FIELD OBSERVATION –REPORT

AEI Project Number and Name: 14018 – The Park Danforth

Observations: 4th FLOOR Walk-through

Sheet 11, Fire Pump
Contract No. 47373NH
Drawn By Benoit
Scale 1/4" = 1'-0"
Date 2.12.16
Approved by ME Stamp

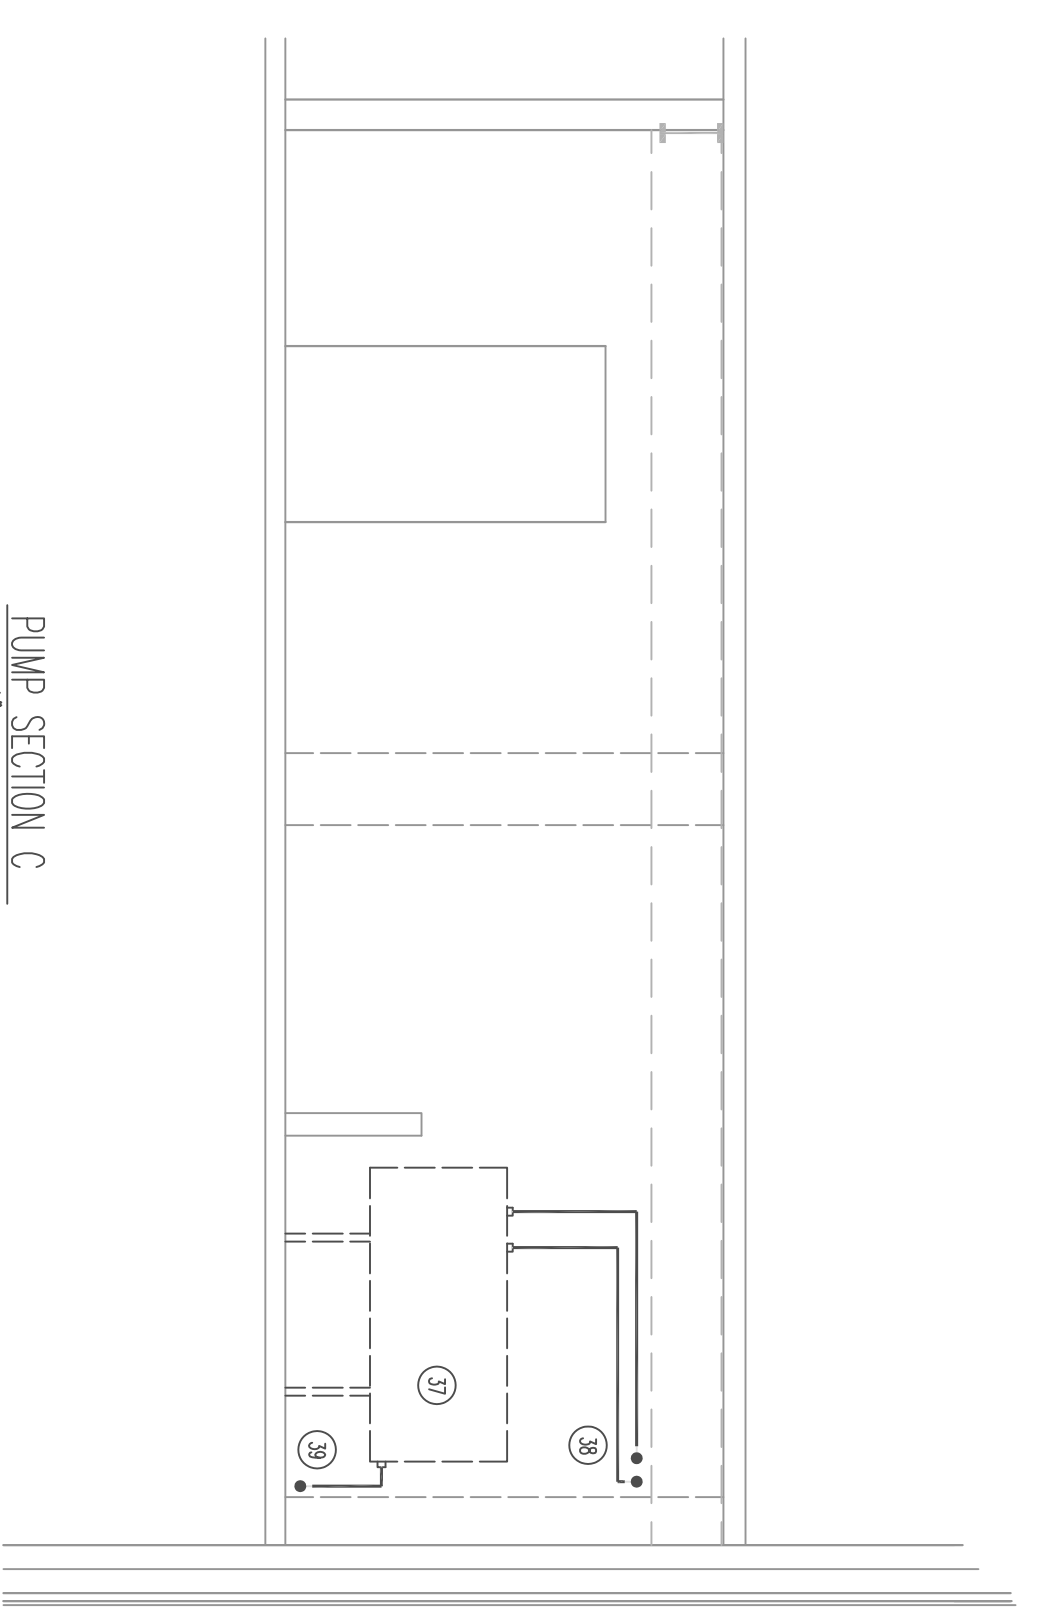
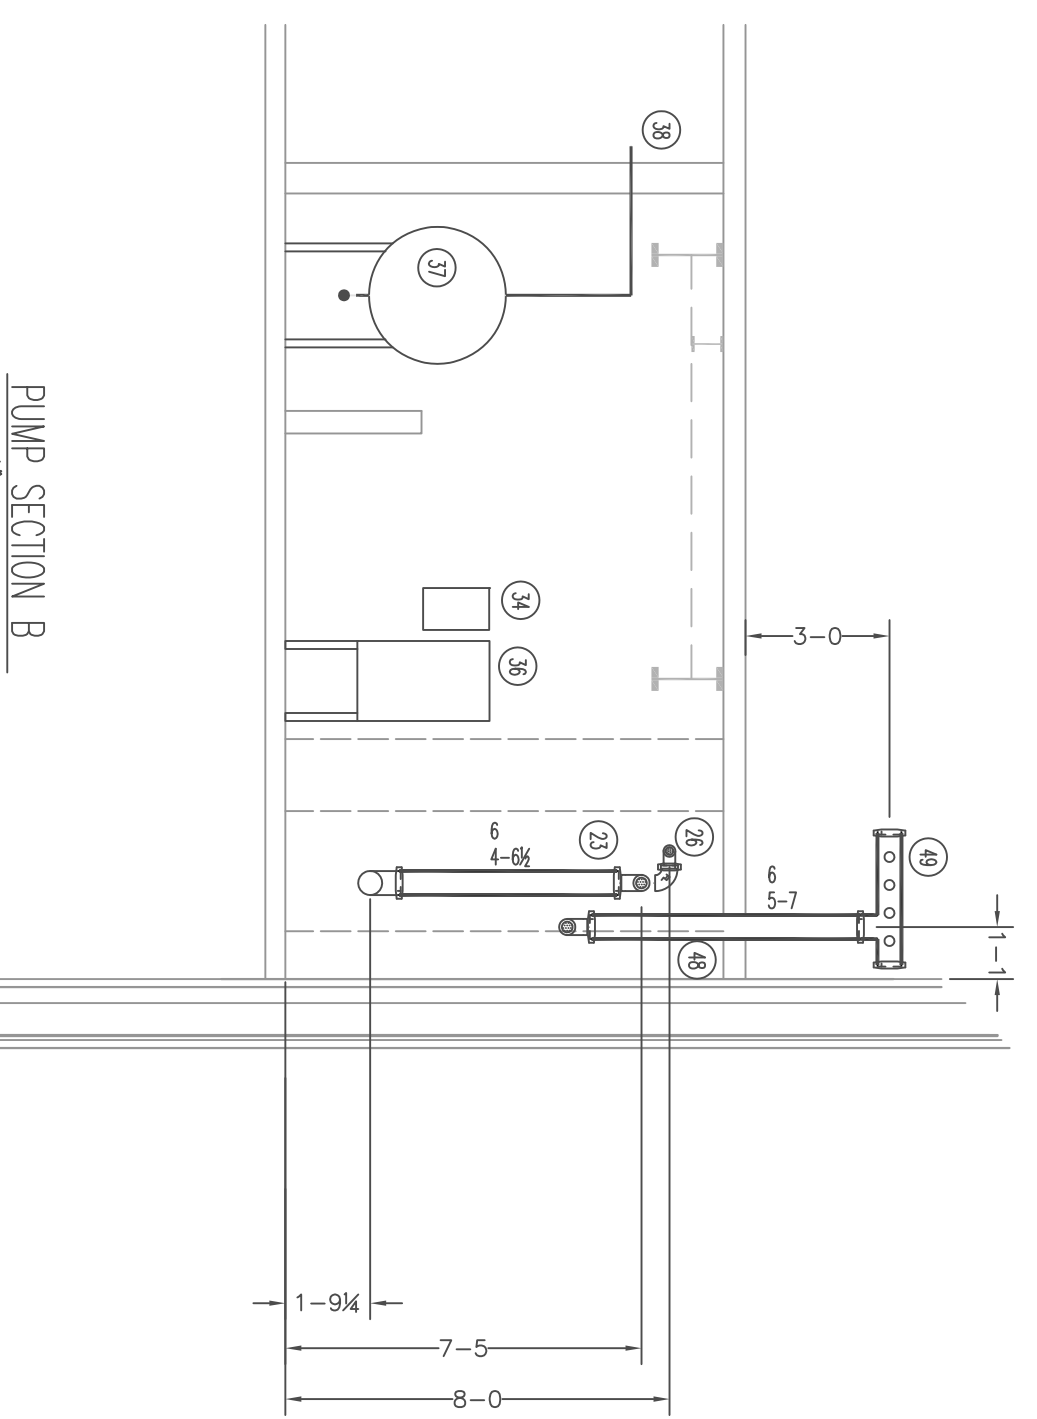
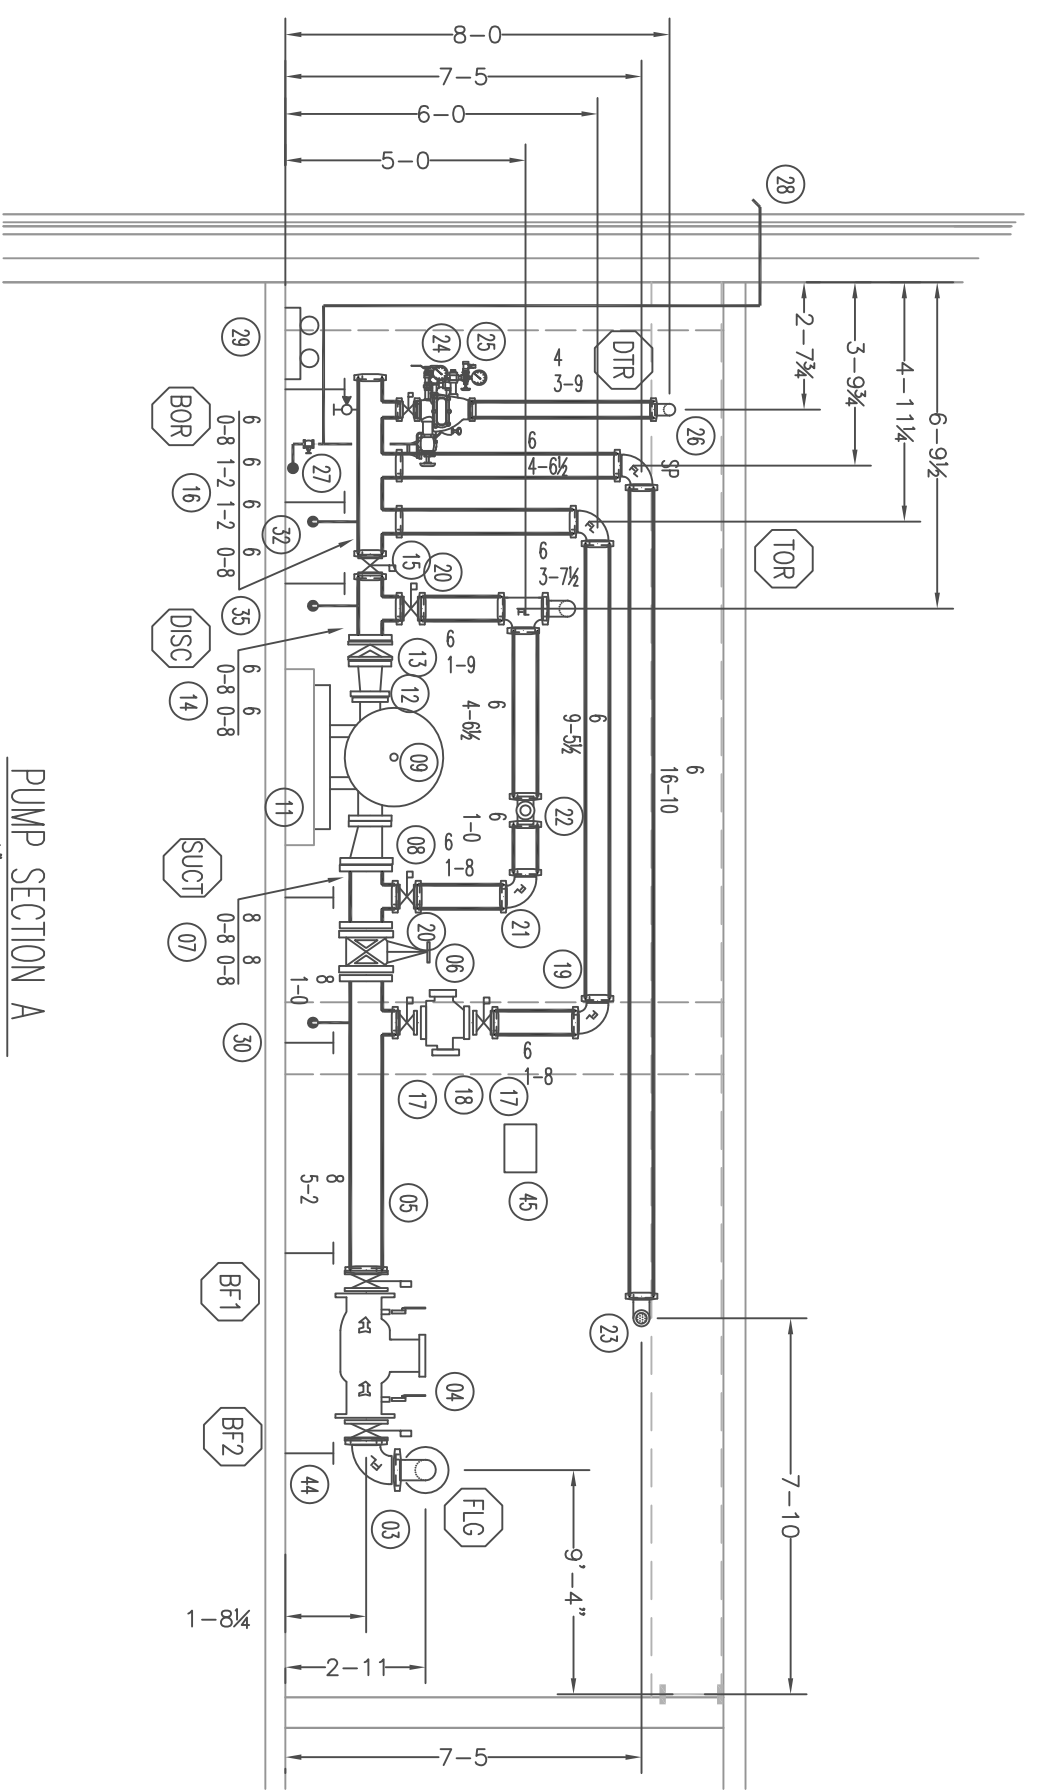
6. Fireproofing missing for fire pump exhaust.
